Rezoning Transportation Analysis

Petition Number: 2023-037

From: Jake Carpenter, PE
Jacob.carpenter@charlottenc.gov
980-221-5675

The site is located at the intersection of Fairview Road, a City-maintained major arterial and Closeburn Road, a City-maintained local street. A Traffic Impact Study (TIS) is not required for this site. All outstanding CDOT comments have been addressed.

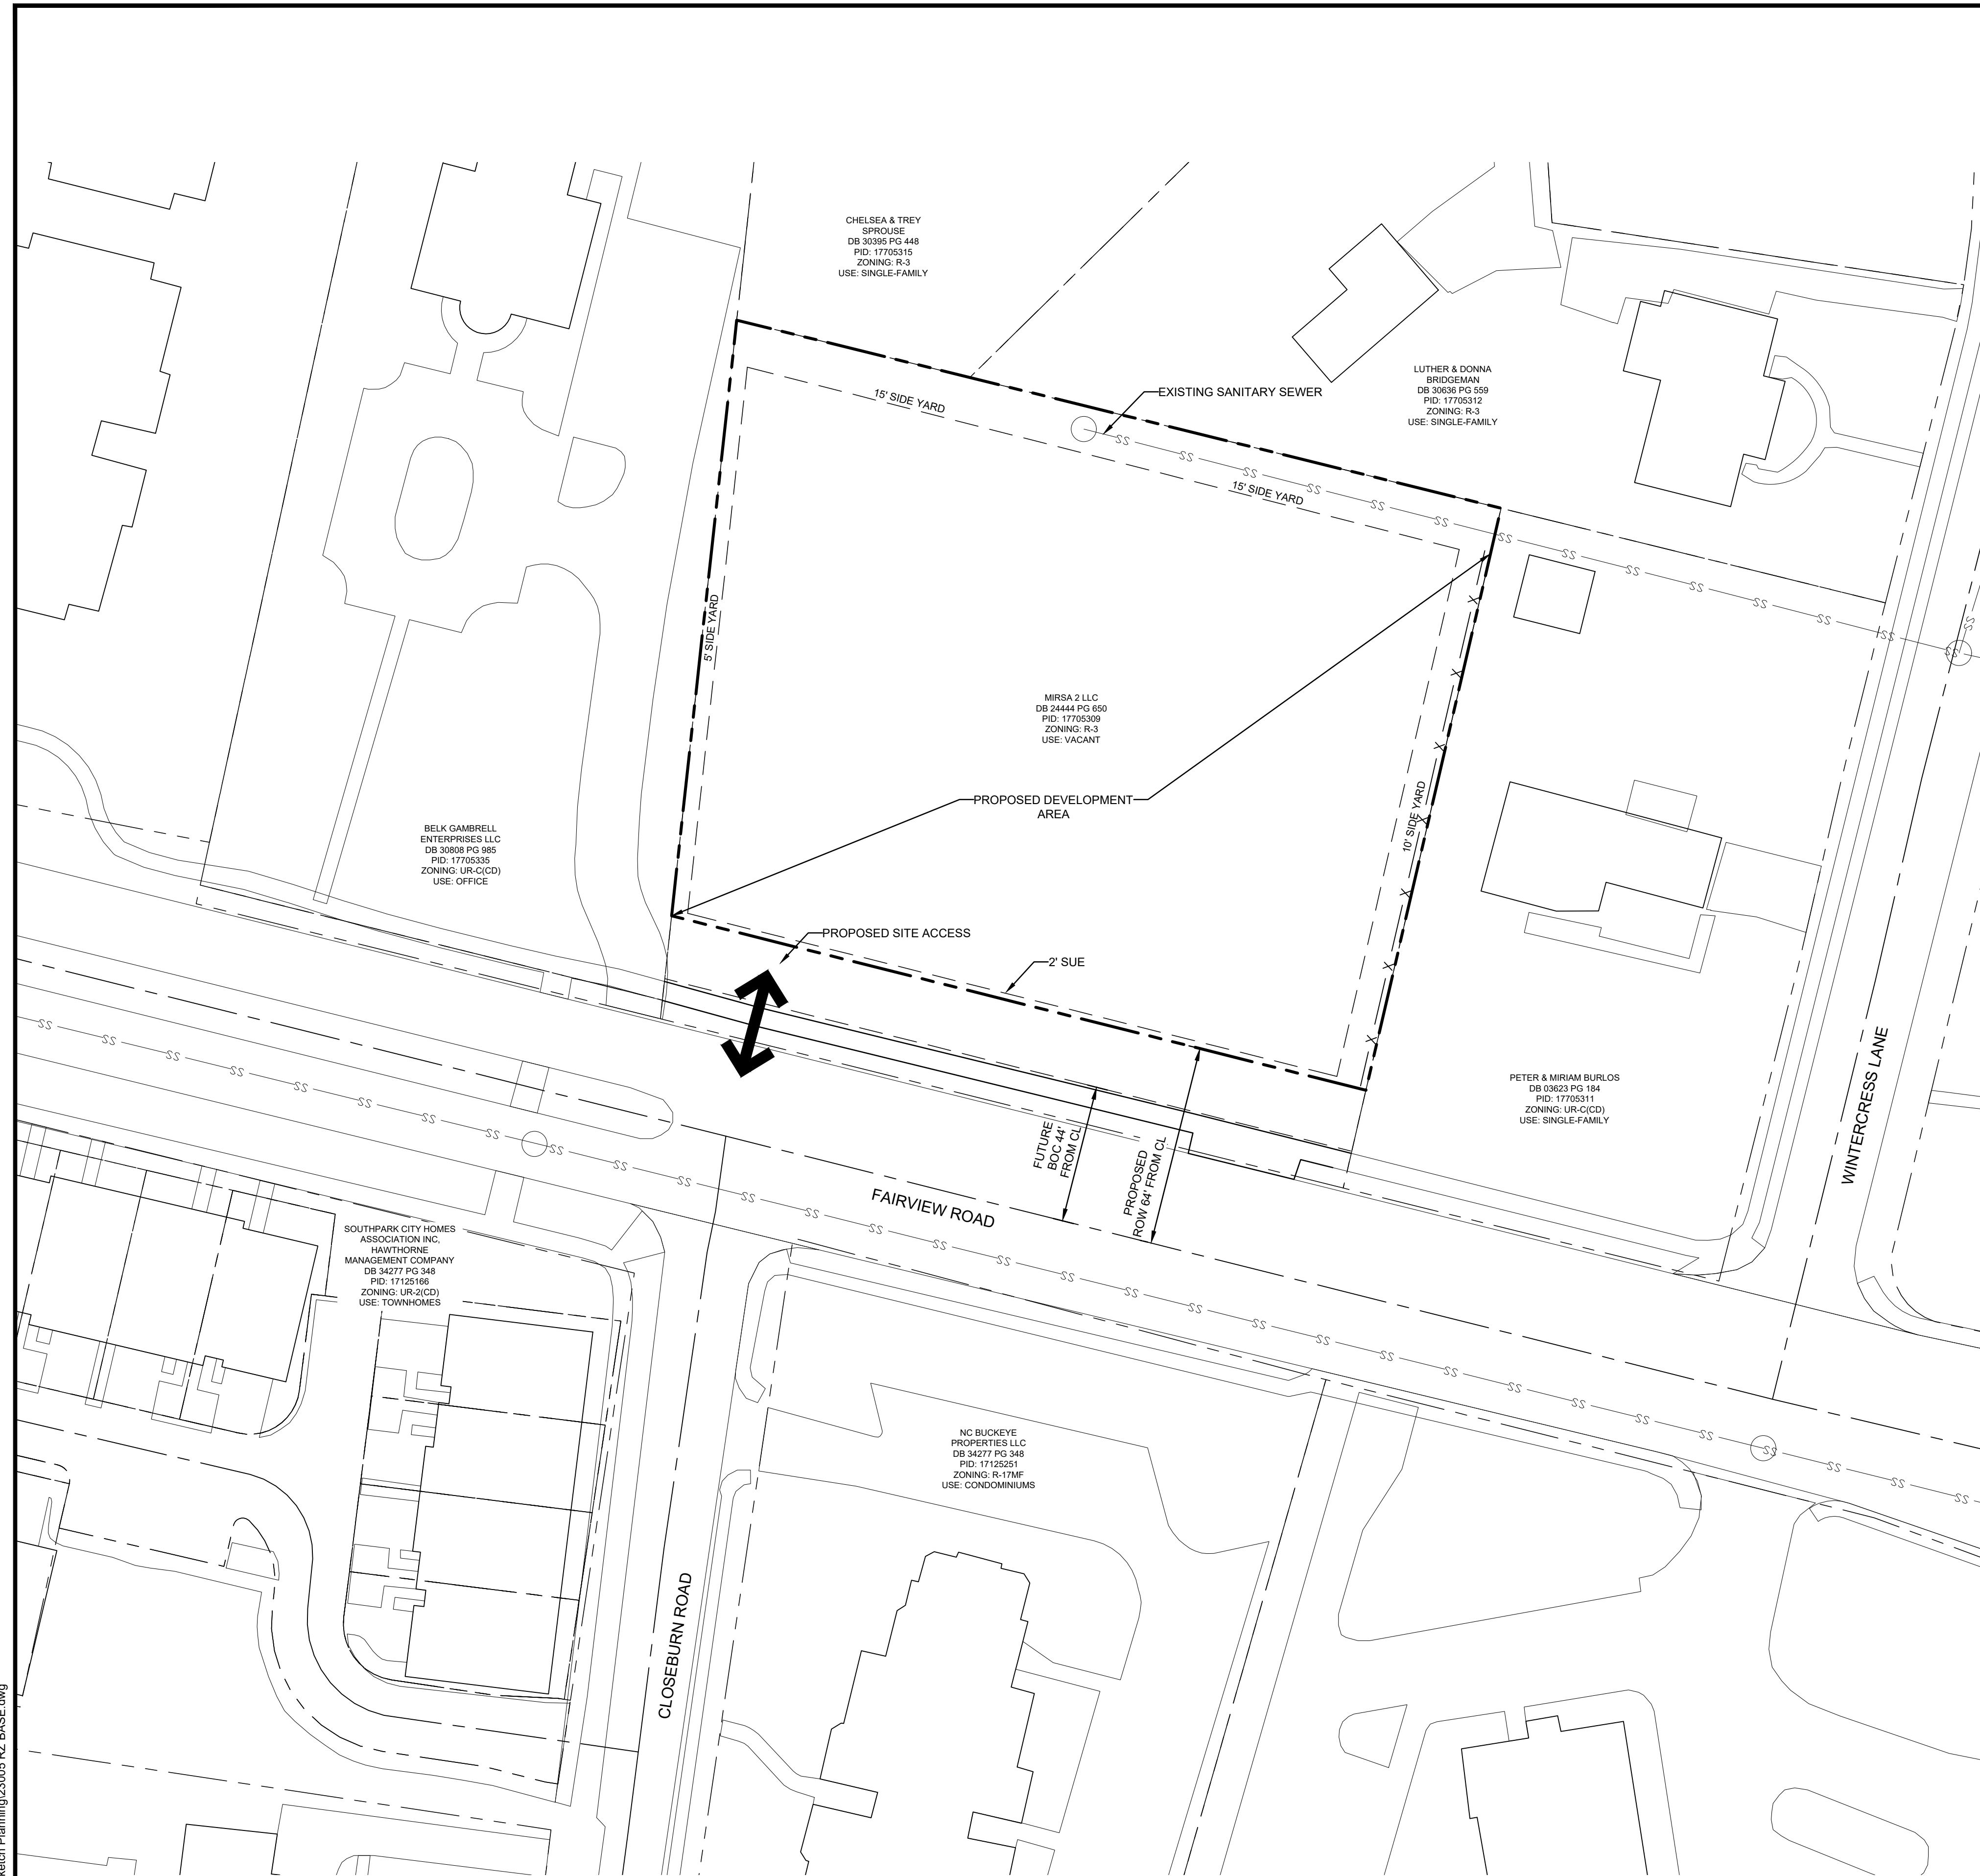
~~**Fairview Road:** Show future location of back of curb and gutter to be 44 feet from roadway centerline to accommodate the Charlotte Streets Map~~

~~NOTE: Additional distance from center line to back of curb may be required in locations where a median is present or around intersections and interchanges.~~

~~Label and dimension the curb and gutter from the centerline for each road on the site plan.~~
